STATE OF NORTH CAROLINA  
DEPARTMENT OF TRANSPORTATION

March 13, 2008

Subject: Request for Section 401 and Section 404 Individual Permit Modification and Permit Extension for Widening of US 15-501 from north of SR 2294 (Mt. Moriah Road) to south of SR 1116 (Garrett Road) in Durham County. Federal Project No. NHF-15 (8), State Project No. 8.1352301, Division 5, WBS Element No. 35012.1.1, TIP No. U-4012.

SITE 1

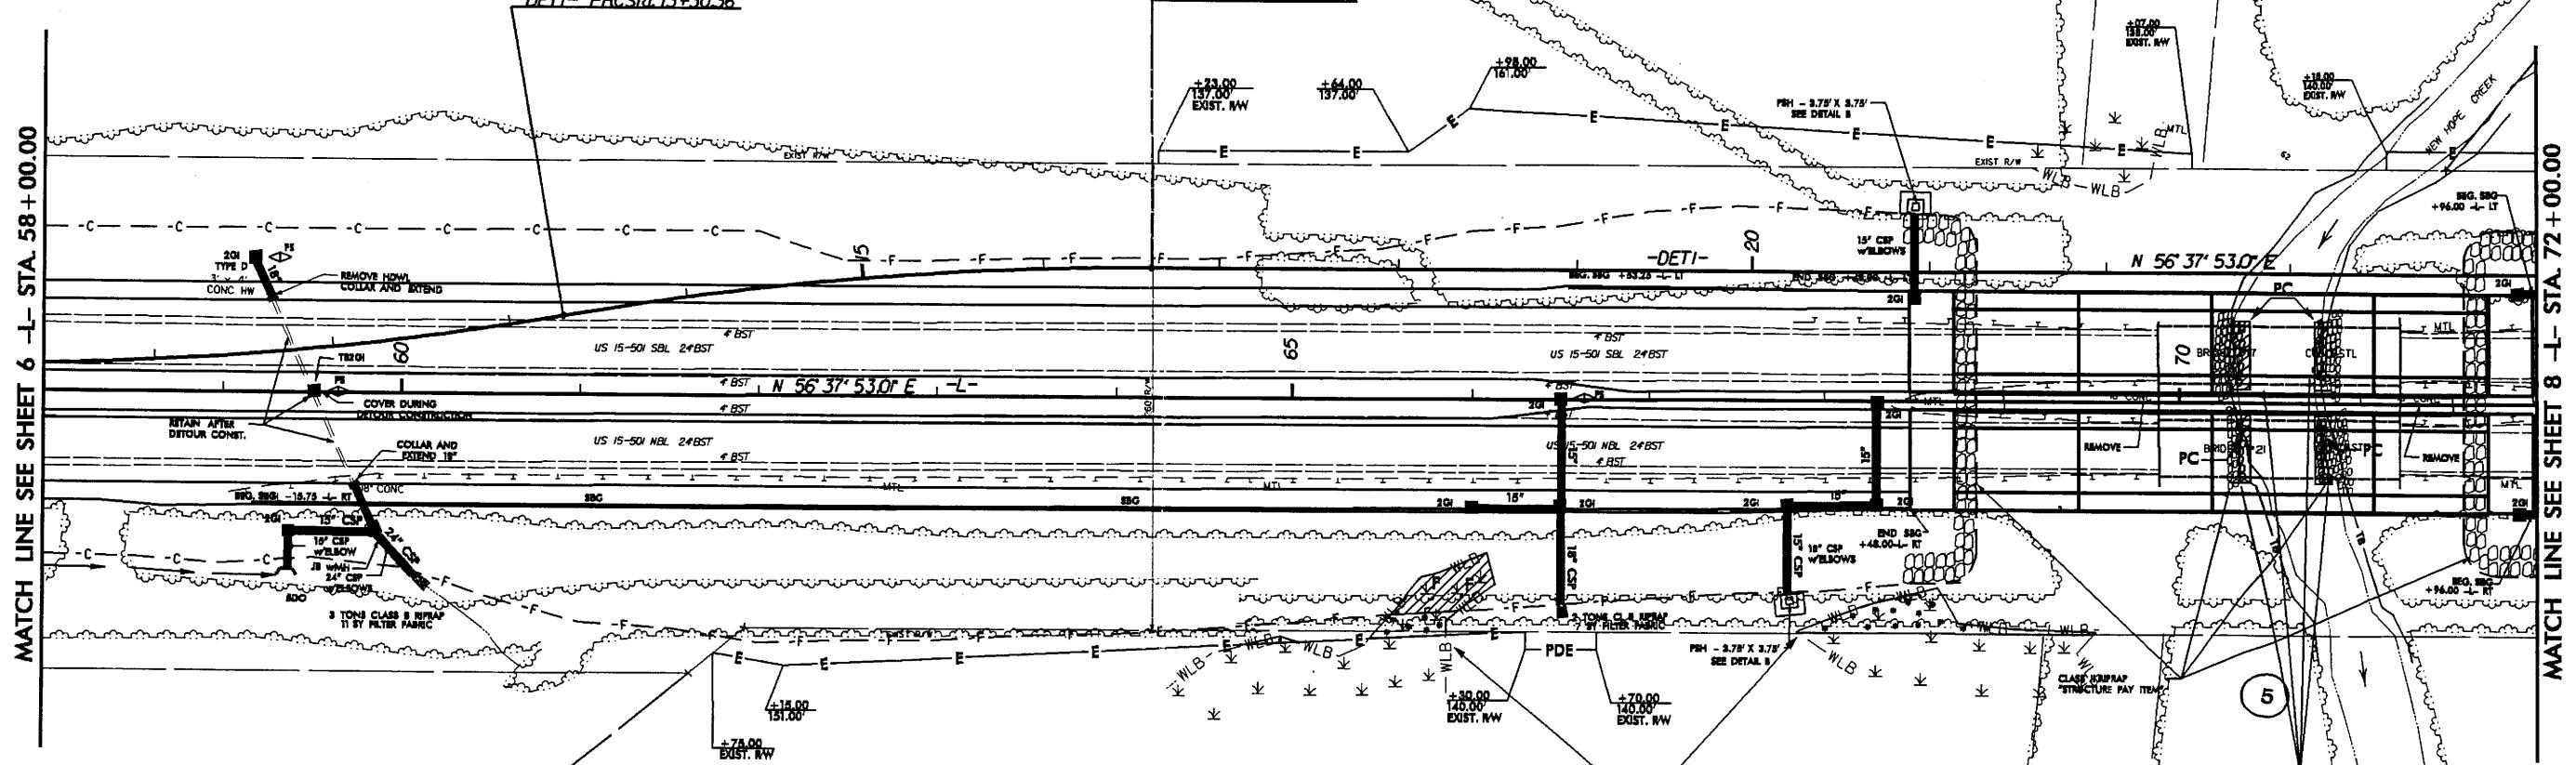
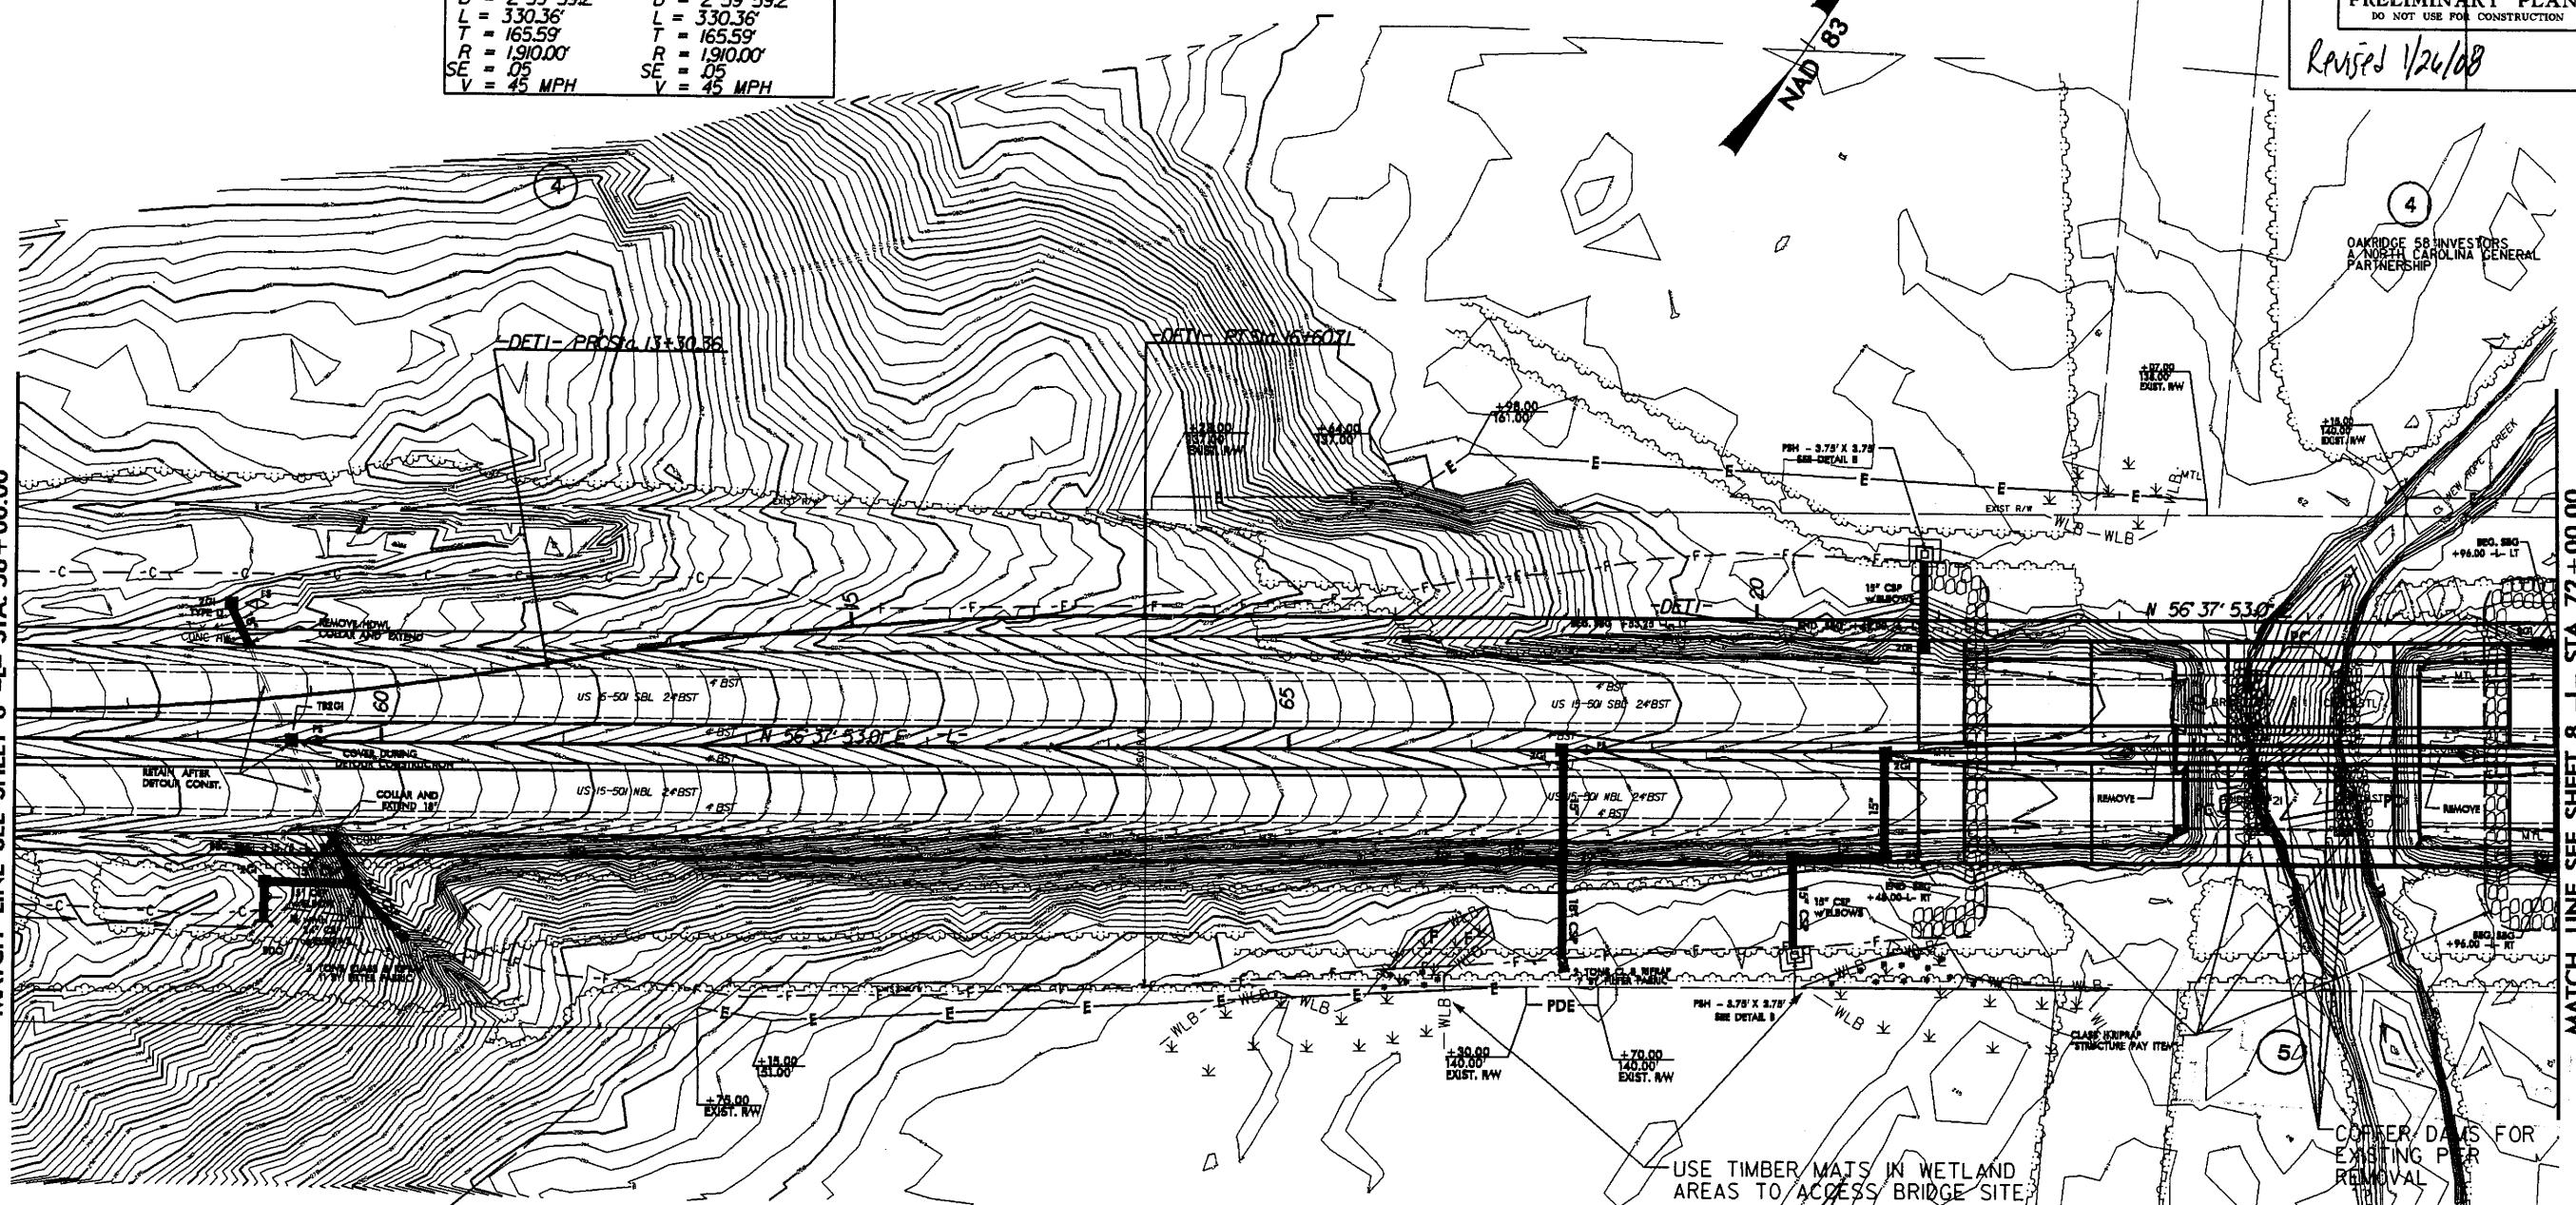
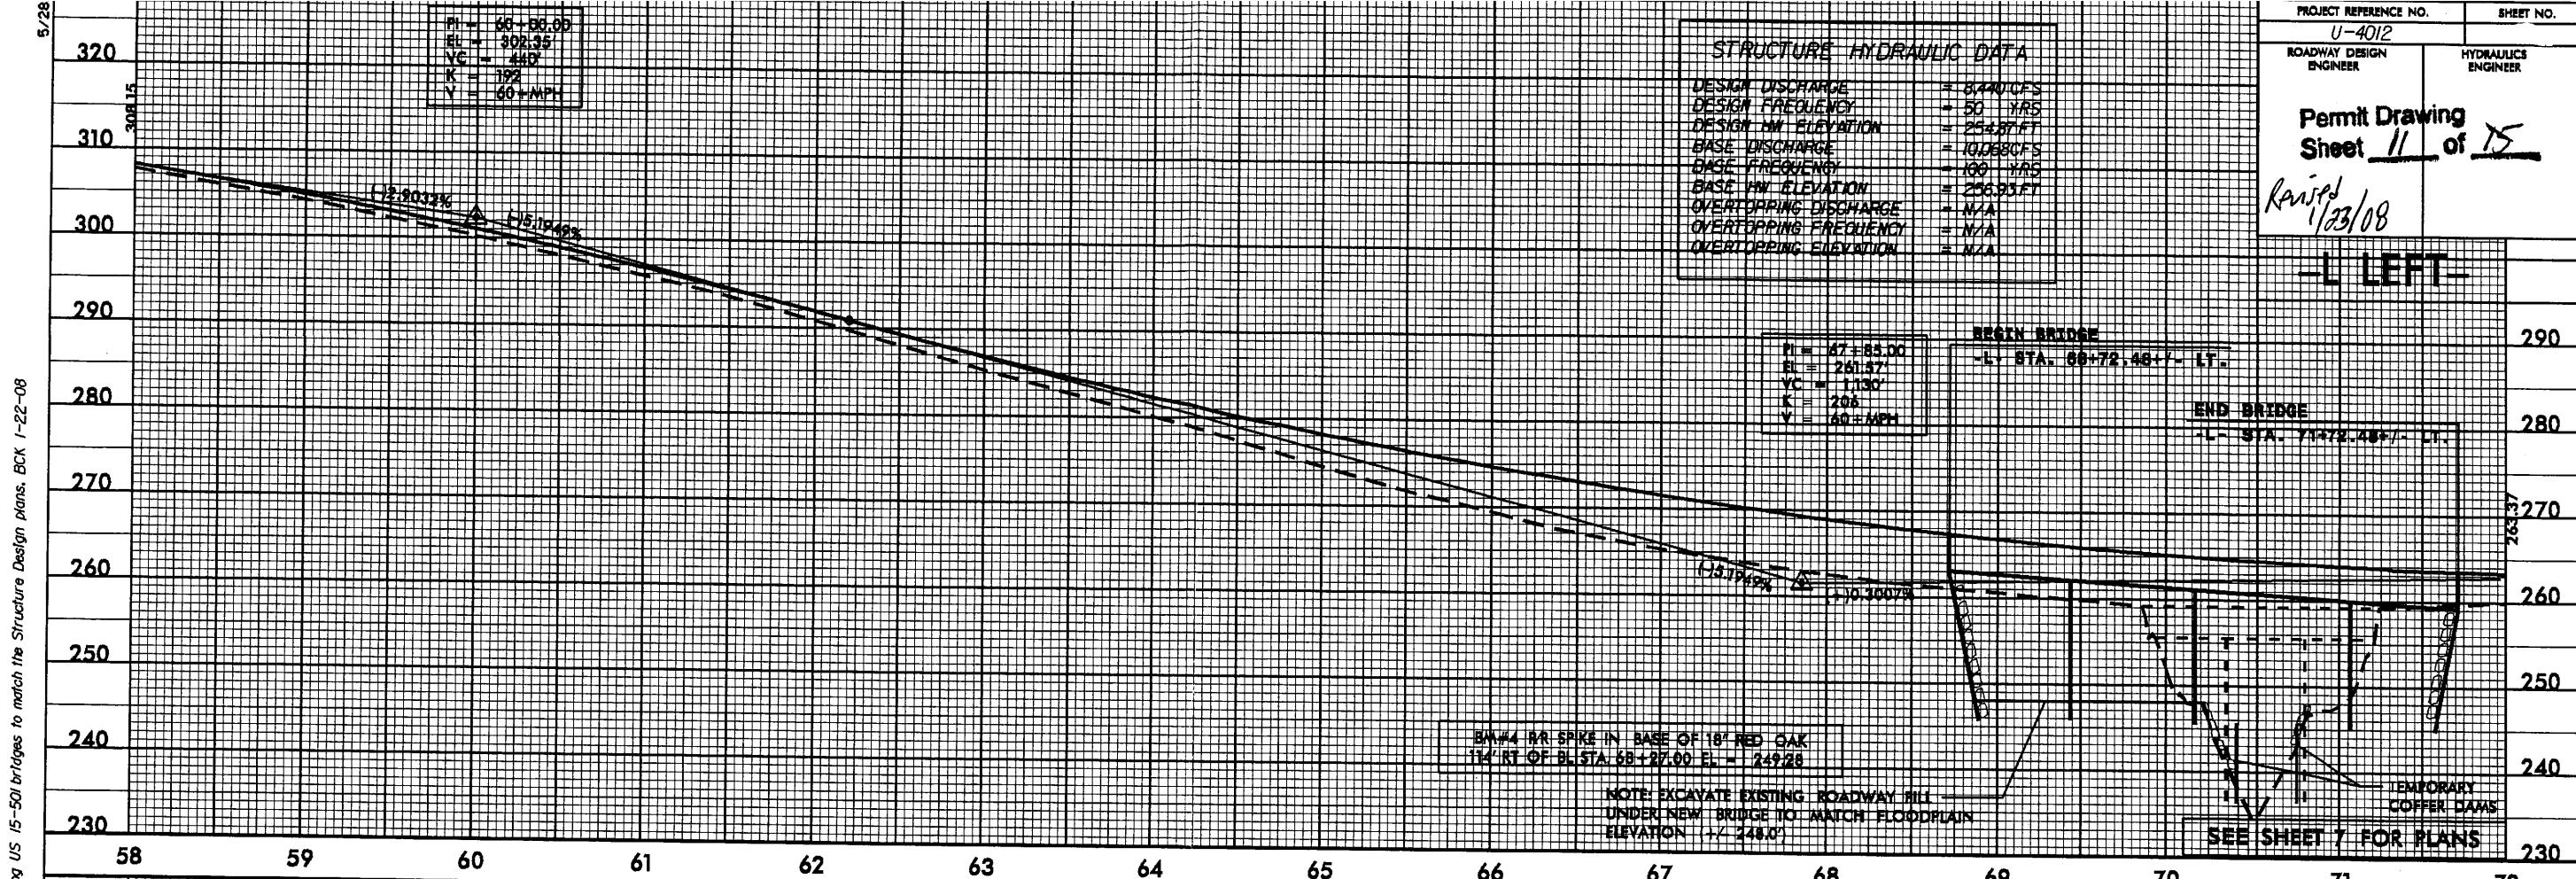
The described changes were to be depicted on the plan and profile views. This information is not depicted on any permit drawings submitted to the regulatory agencies as part of the permit application dated December 13, 2004. The attached revised permit drawings 3, 7, 11 and 14 of 15 indicate the permanent installation of Class II rip rap below normal water surface on New Hope Creek at 70+35 and 70+75 -L- to stabilize the stream banks after removal of existing piers.

Jurisdictional Changes: The installation of Class II rip rap below normal water surface on New Hope Creek at 70+35 and 70+75 -L- will result in an additional 72 linear feet of permanent stream impact due to bank stabilization. The revised plan sheet 7 is also included.
